From: Martin Hill <Martin.Hill@arun.gov.uk>
Sent: 23 July 2020 15:19
To: Planning.Responses <Planning.Responses@arun.gov.uk>
Subject: RE: Planning Consultation on: BR/162/20/PD

Application No: BR/162/20/PD

Site Address: 34 Sudley Road Bognor Regis PO21 1ER

Description of Works: Notification of prior approval under Schedule 2, Part 3, Class O for the change of use of 3 storey office (B1(a)) to 3 No flats (C3 Dwelling houses).

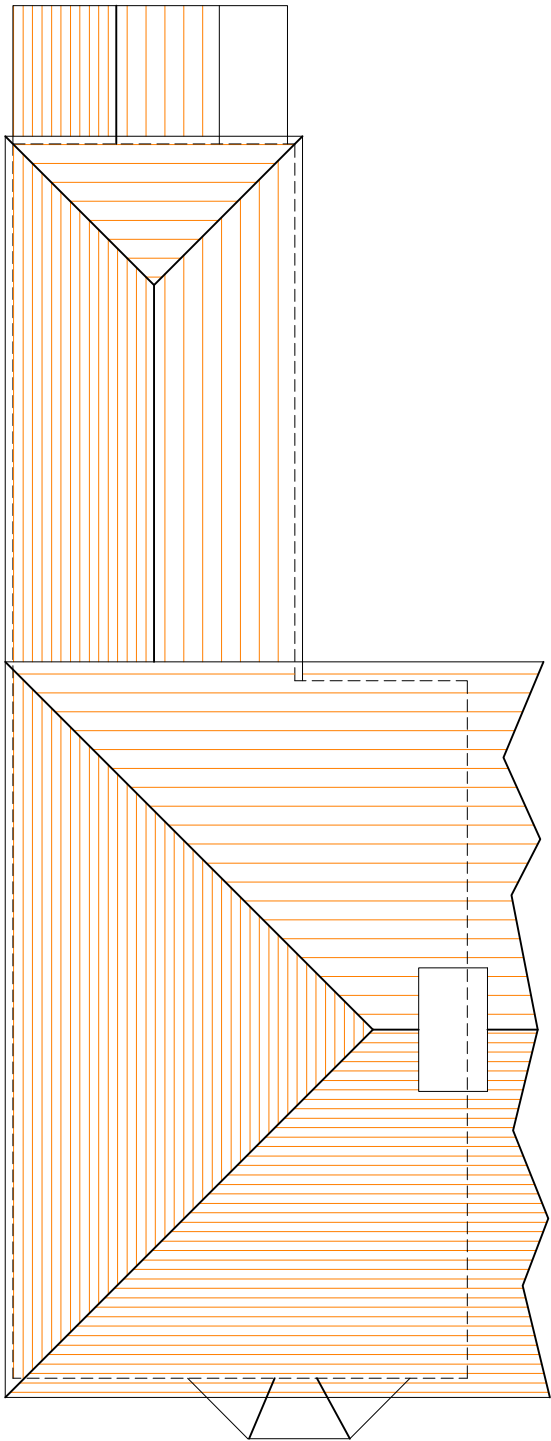
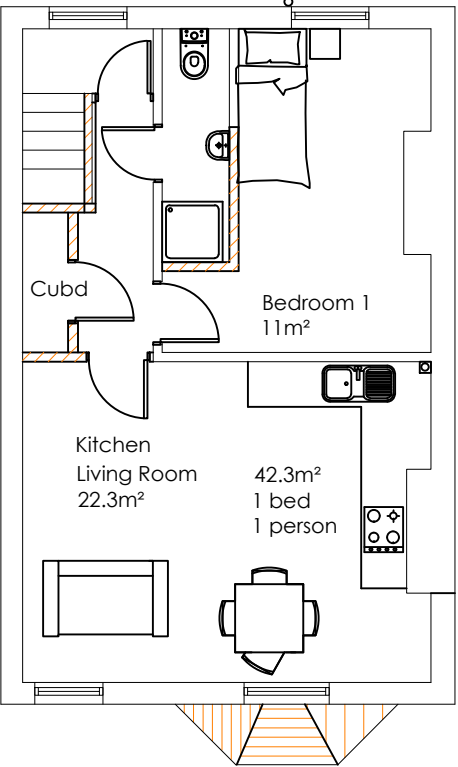
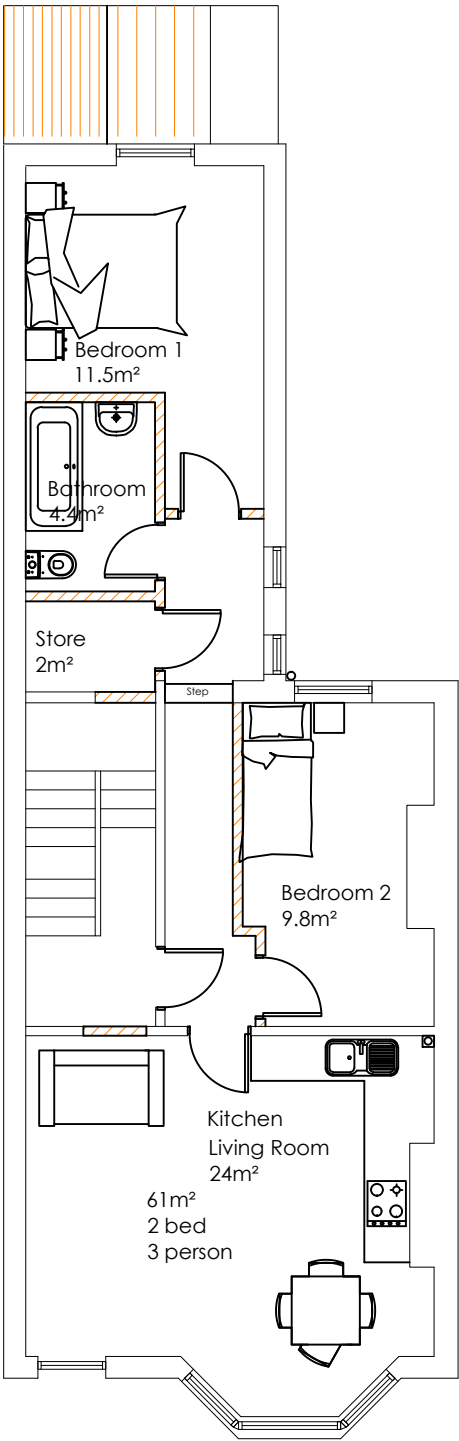
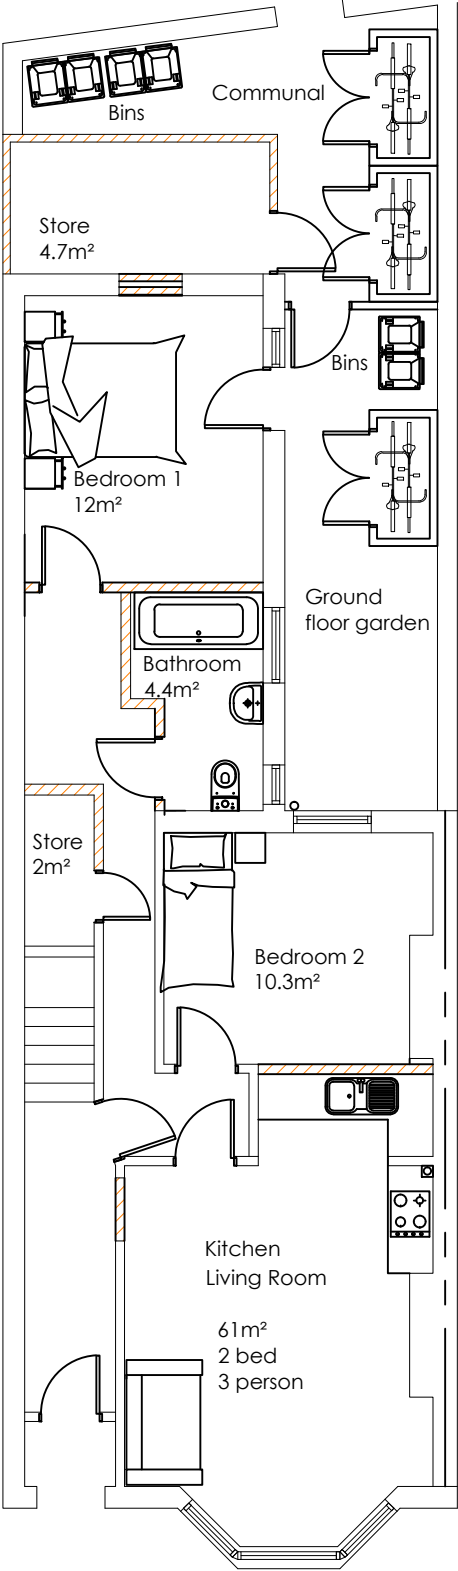
- The windows between bedroom 2 and the hallway of the first floor flat appear to be less than 1.8 metres apart. The window(s) within 1.8metres of bedroom 2’s window in the hallway should be replaced with fire resisting glazing, which is non-openable, in order to prevent fire spread from one part of the flat to another and possibly compromising the escape route serving the other bedroom (bedroom 1).

detection is required in any areas, such as the under-stairs, being identified as a risk area. According to the submitted floor plan proposal, there are storage areas on the ground and first floors that may extend beneath the staircase and these areas must be assessed for fire risk and appropriate fire precautions implemented.

- o The window casement of bedroom 1 in the ground floor flat does not appear to provide an openable area of at least 1/20th of the total floor area of the room. Furthermore, the proposed window and door from this bedroom opens into a narrow area and looks directly to a bin and cycle storage area. The occupants of bedroom 1 in the ground floor flat must be provided with adequate privacy from the outside, in and the window casement must have an openable area of at least 1/20th of the total floor area of the room. The cycle storage and bins proposed to be sited directly outside bedroom 1 of the ground floor flat should be re-located to the other, larger storage area designated for bins and cycles at the rear of the property and the garden area should be separated, such as with a fence and gate, for example to help overcome the privacy and noise issues the current proposal poses.
